Comments for Planning Application 21/00278/FUL

Address: 1 Northmoor Road Oxford OX2 6UW

Proposal: Demolition of existing rear conservatory. Erection of a single storey rear extension.

Comment: Objection to planning request No 1 Northmoor Road, OX2 6UW

Title  
**PROPOSED ELEVATIONS 02**

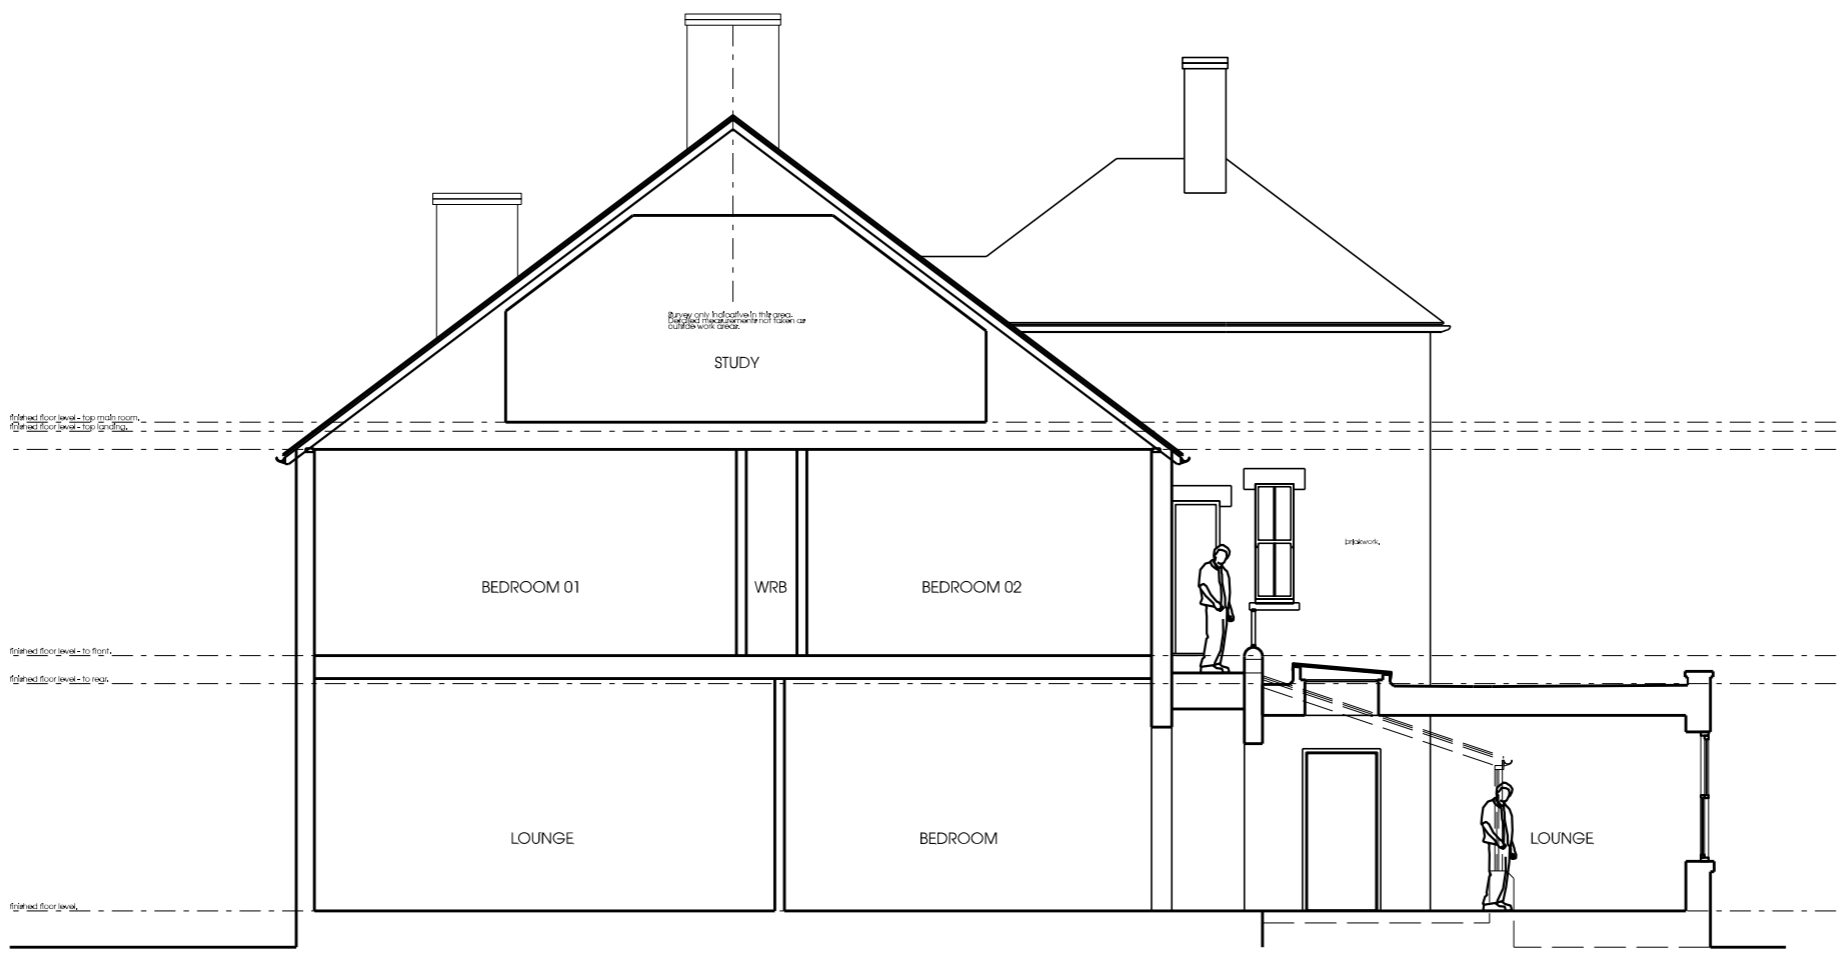
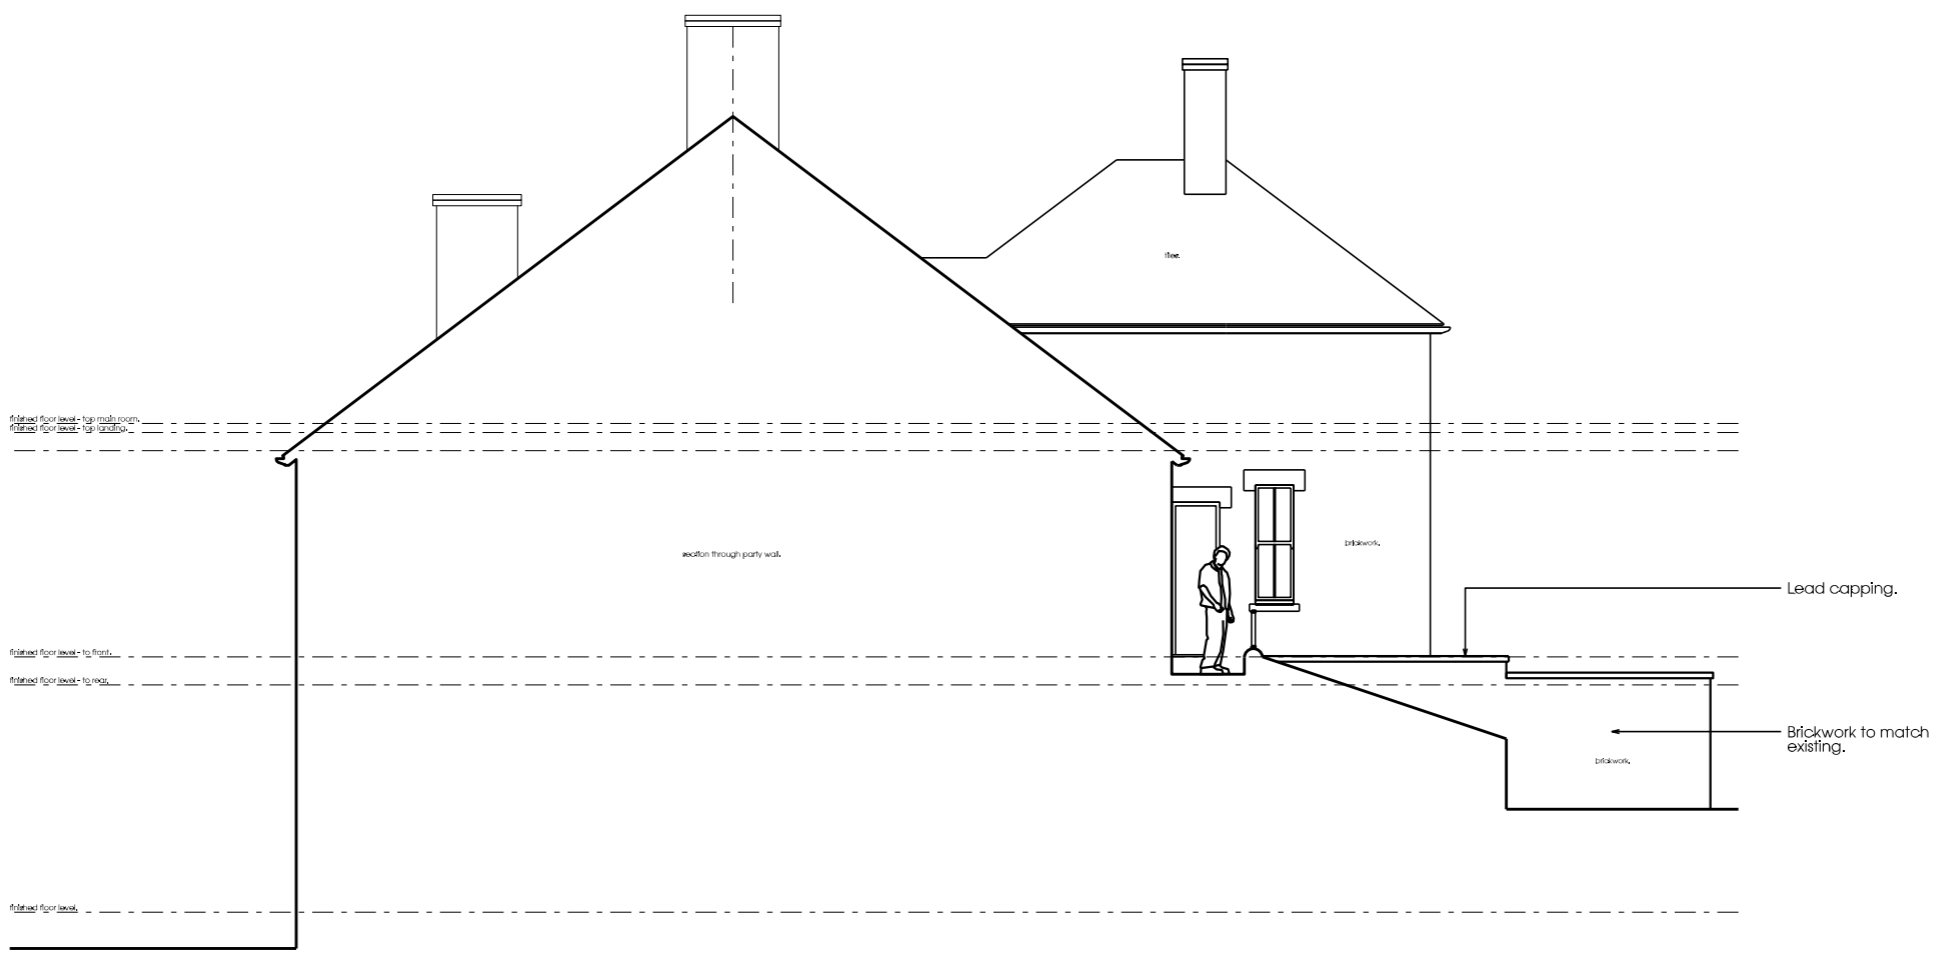
Not only this conservatory would be affected, but also our kitchen and dining room (which are already darkened by the massive fir tree at the bottom of Mr Johnson's garden). The proposed extension would stretch some 3 metres out along our boundary wall, stepping down to a slightly lower height of approximately 2.60m, and creating an ugly brick mass that we would be confronting every day of our lives. Our views south from our dinner table would be irreversibly marred.

Mr Johnson's architect has simply ignored both these effects in his submitted drawings. Our line of sight would be far more impaired than shown on his sketch, as indicated by the more thorough analysis of our own architect.

PROPOSED ELEVATIONS 01

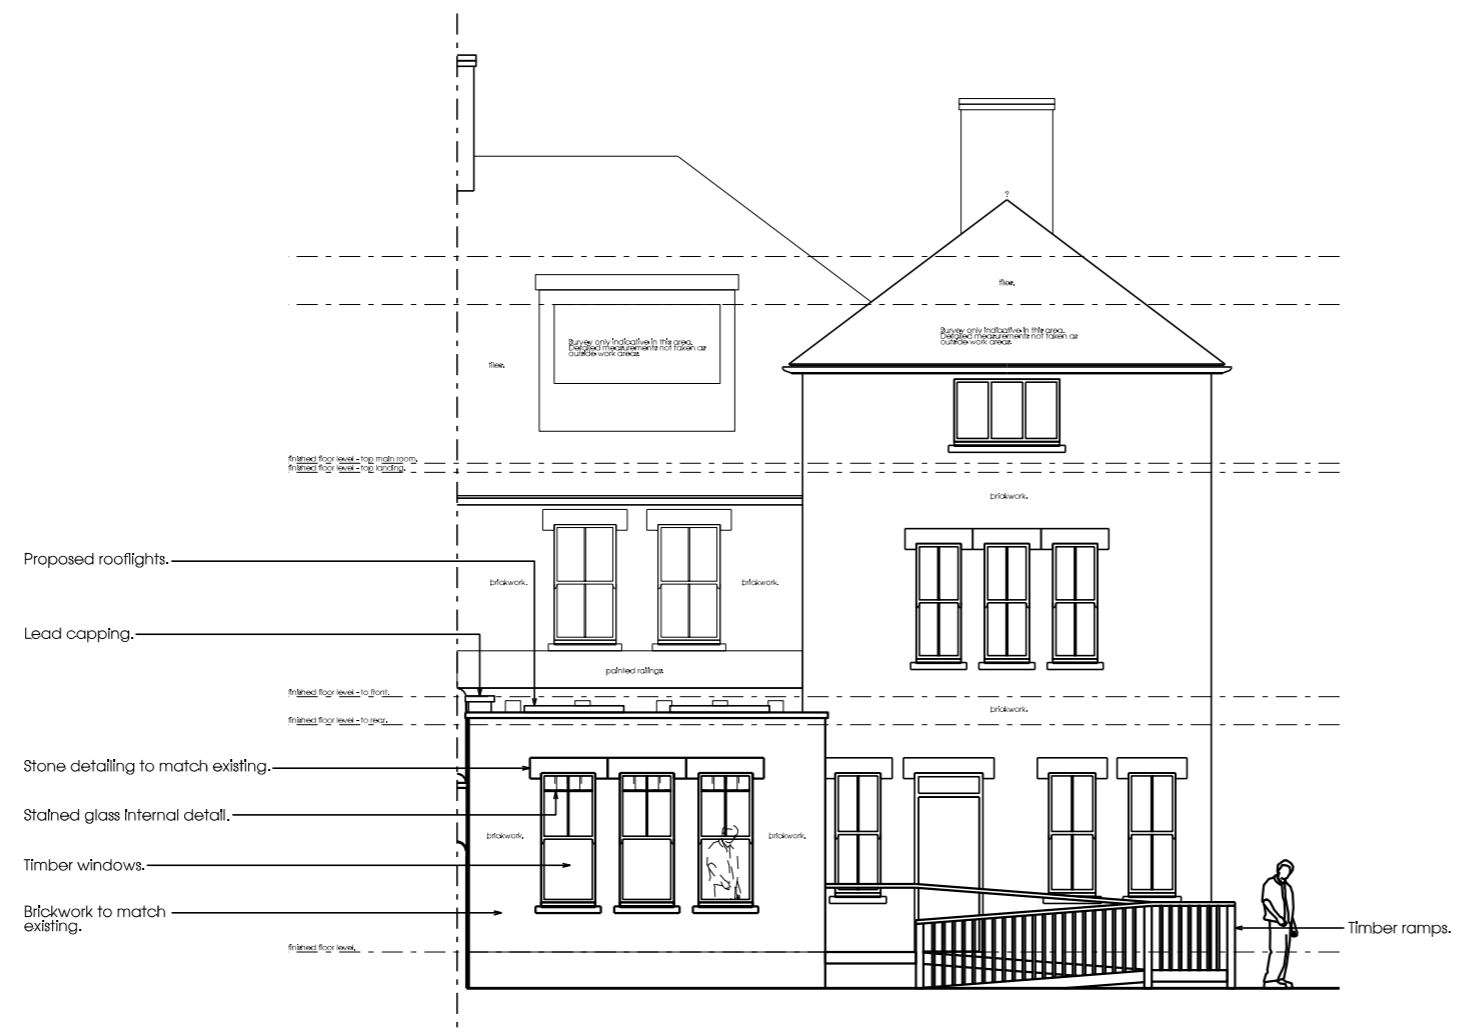
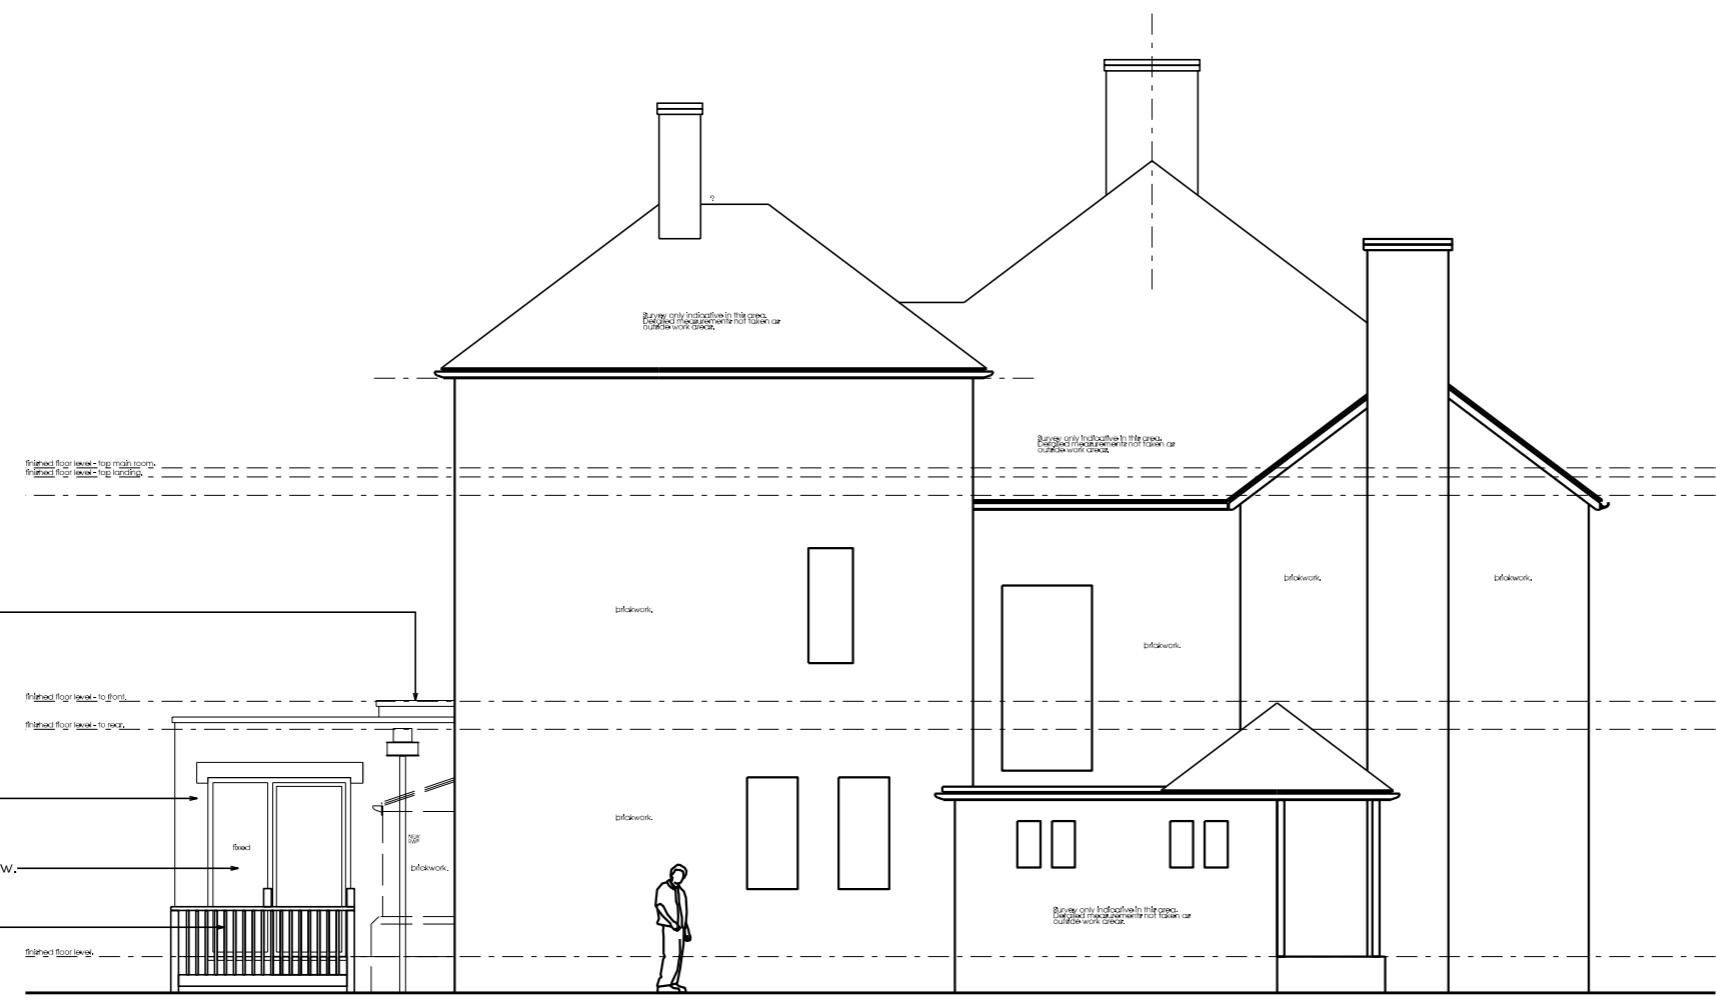
We are not aesthetically dogmatic, but this structure is unambiguously ugly and would involve the loss of an attractive fig tree (confirmed by Mr Johnson), that in summer is beautiful. The flat roof

jutting out from the bottom of the first floor; the high, bulbous skylight windows; the square, uncompromising lines of the extension itself; and the west-facing window that fails to match in any way those already existing in both houses in our Conservation Area would all be jarring to the eye. We should also note that the proposed elevated height of the floor level in the extension would give this west-facing window a direct and intrusive view over the boundary wall onto our patio, where we have our meals in the summer.
